KITITAS COUNTY

DEPARTMENT OF PUBLIC WORKS

MEMORANDUM

TO: All Staff
FROM: Public Works Plan Review Team
DATE: January 12, 2026
SUBJECT: BL-25-00023 Rinehart

**EXISTING**

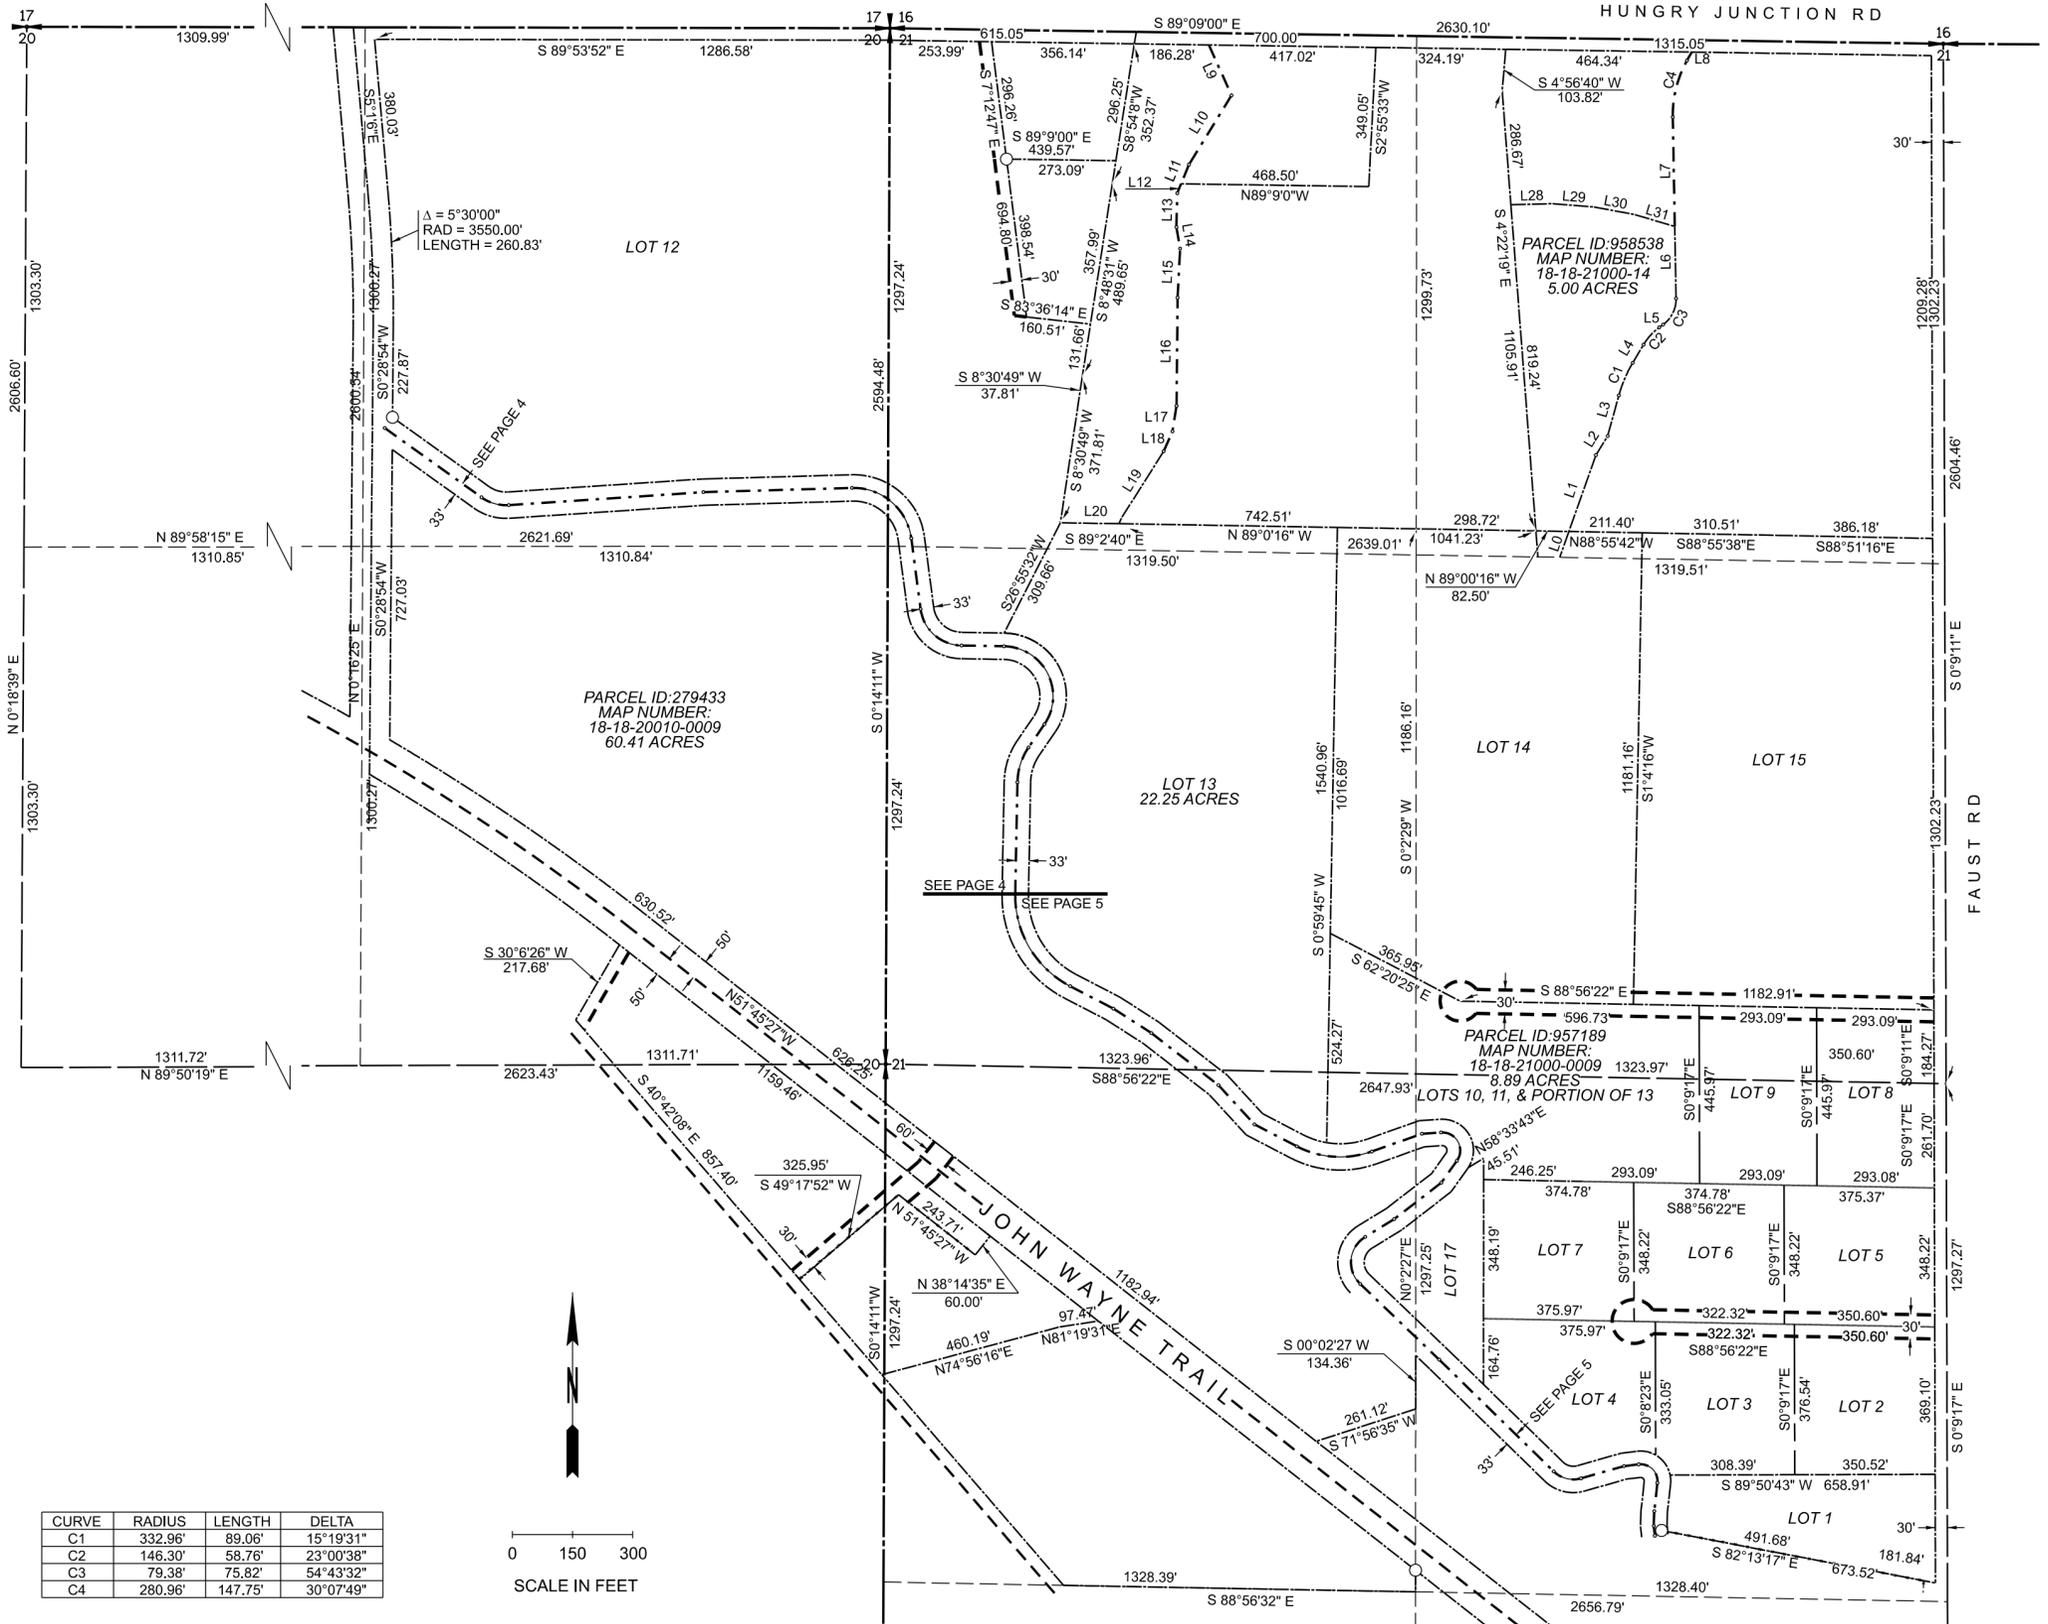
<p>SURVEY</p>	<p>OF NOTE</p> <p>Survey comments are based upon the submitted pages, which consist of Sheets 1, 3, 5, 7 and 8.</p> <p>Lot Closures were not included and the application and will need to be approved prior to final approval. Once Lot Closures are received it may trigger additional responses regarding dimensions or lot areas.</p> <p>All Sheets:</p> <ol style="list-style-type: none"> 1. At the top of each sheet include a heading showing "Record Of Survey - Pt Sec's 20 & 21 T18N., R18E., W.M. Kittitas County, Washington" (or similar). 2. Please include Set Corners and Found Corners in the legend. 3. At a minimum, the new division lines between parcels shall have corners set in the field and shown on the face of the survey. 4. All road Right of way must include ownership, total width, and surfacing. (EX: Faust Rd – 60' Wide County R/W – Paved) 5. John Wayne Trail should be changed to "Palouse to Cascades State Park". 6. Show all existing buildings, access points, fences, ponds, and water courses. Buildings and fences shall include distance ties to nearest boundary. Water courses shall be identified as creek, ditch or canal. Include Reecer Creek 7. Town ditch shall be labelled as "Town Ditch-Ellensburg Water Co. R/W (or similar). 8. Outside perimeter of development shall be drawn in a heavy line. 9. Section corners and controlling survey evidence, shall be identified as found, set or calculated with a description of the point (EX: N1/4 Sec 8, Fnd 3-1/4" Brass Cap in Conc Post, "PLS 12345") 10. All easements shall include width, purpose, and whether they are existing or "to be created via separate document". In the case of existing easements, include the recording number. 11. Where a parcel crosses a section line, or other reference line, please include a 'Z' symbol to clarify that the two parts belong to the same parcel. 12. There are multiple occurrences of text being obscured by crossing linework. <p>On Any Sheet in set</p> <ol style="list-style-type: none"> 13. A Survey Equipment and Procedures statement must be shown. 14. The purpose of the survey with reference to the application number must be shown (EX: The purpose of the survey is to depict proposed new boundaries for the parcels shown, in order to facilitate Boundary Line Adjustment Application No. BL-25-00023) (or similar) 15. Identify Basis of Bearing or include note identifying Basis of Bearing. 16. Include before and after legal descriptions for the involved parcels. (NOTE: Per new RCW/WAC Updates, Legal description must include BOTH complete legal description AND reference to the recording document.) <p>Sheet 1</p> <ol style="list-style-type: none"> 17. Change 'Sheet 1 of 1 to 'Sheet 1 of 8'.

DATE: 11/30/2025	SCALE: 1" = 300'	JOB: 2024006
DRAWN BY: KLC	CHECKED BY: KLC	PAGE 3 OF 8

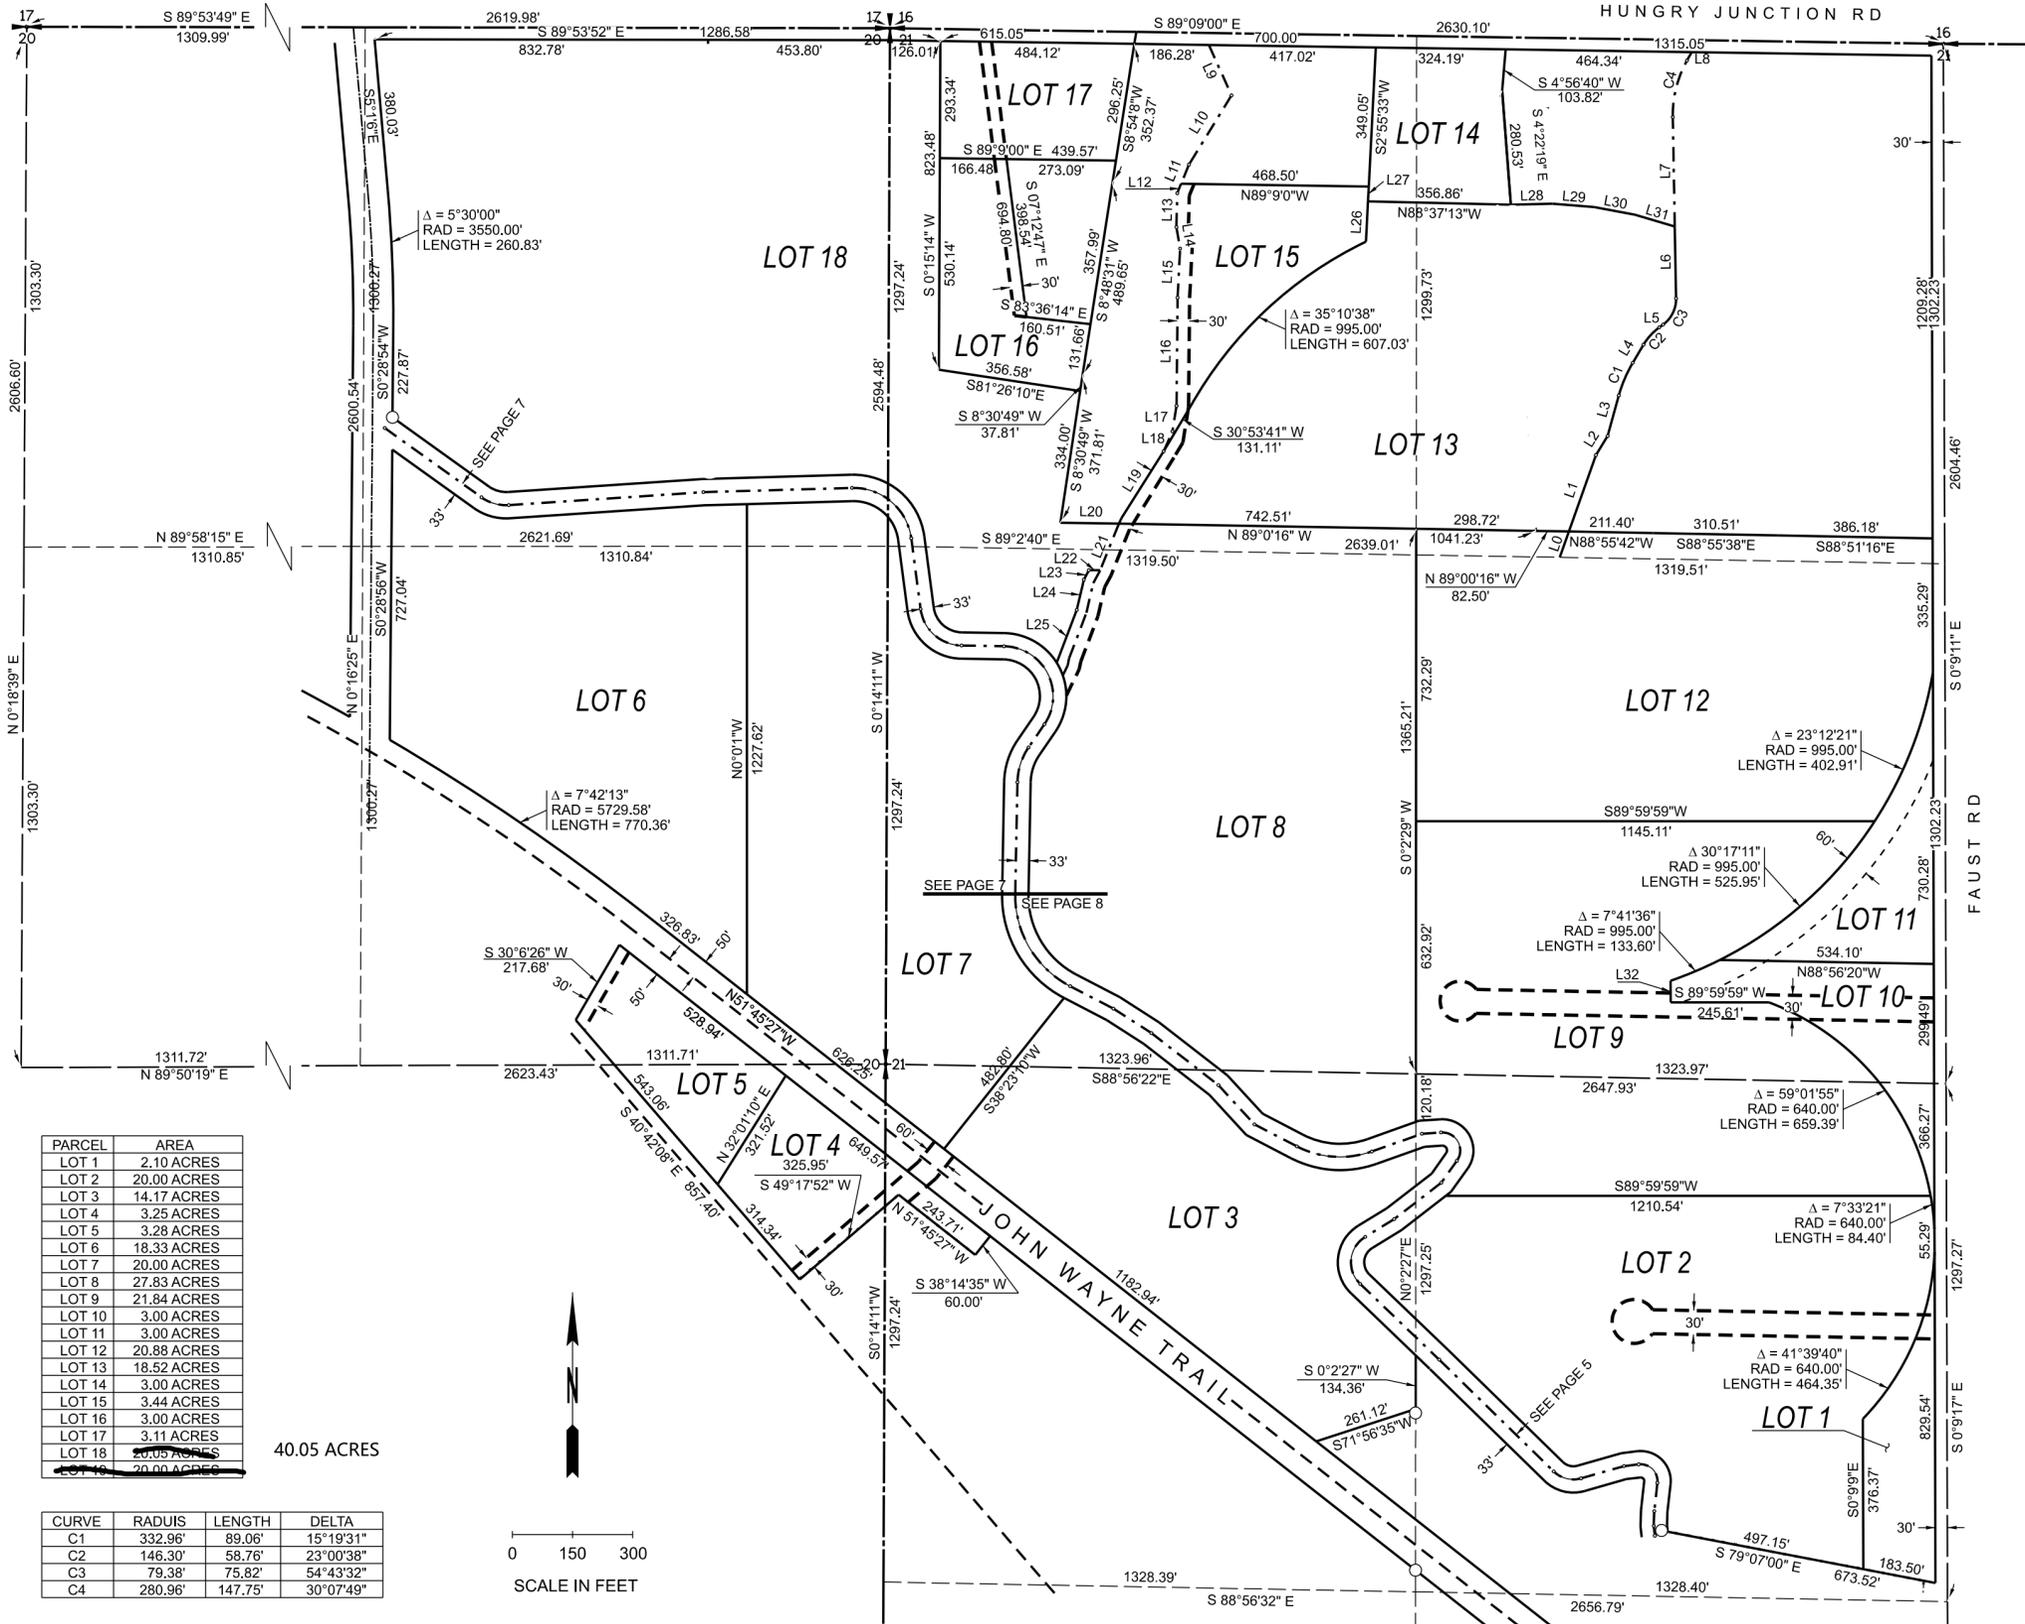
<p>18. If the 'Round Structure' on Lot 18, is construed as a building, the new line will need to meet setback requirements.</p> <p>Sheet 3</p> <p>19. The unidentified parcel located adjacent to the NE Corner of Existing Lot 12 does not appear to be a unique parcel per county GIS. Please show this as being a portion of Lot 12 or notify county if there is a GIS problem. This element also puts the total lot count of 17 existing, and 18 proposed, which will either require a lot removed from the proposed development, or resubmit as a Short Plat.</p> <p>20. All existing parcels should include a reference to the recording number (EX: Lot 12- Bk:37, Pg:89, Surveys OR Lot 12, Sur:37-89 OR Lot 12- AFN:20101220027).</p> <p>21. Parcels not included in the development, such as APN:345636 would benefit from being labelled as "Not A Part".</p> <p>22. The corner located near the SW corner of Lot 1 appears to be a witness. Please include offset angle and distance.</p> <p>Sheet 4</p> <p>23. Curves not adjacent to tangent lines, such as East boundaries of Lots 2, 9 and 12, will need to include radial bearings OR Chord bearing and distances.</p> <p>24. There are property corners shown that appear to be witness corners that will need to include angle and distance offsets. These include the corners near the SE'most corner of Lot 3, and the SW'most corner of Lot 2. (JT)</p>
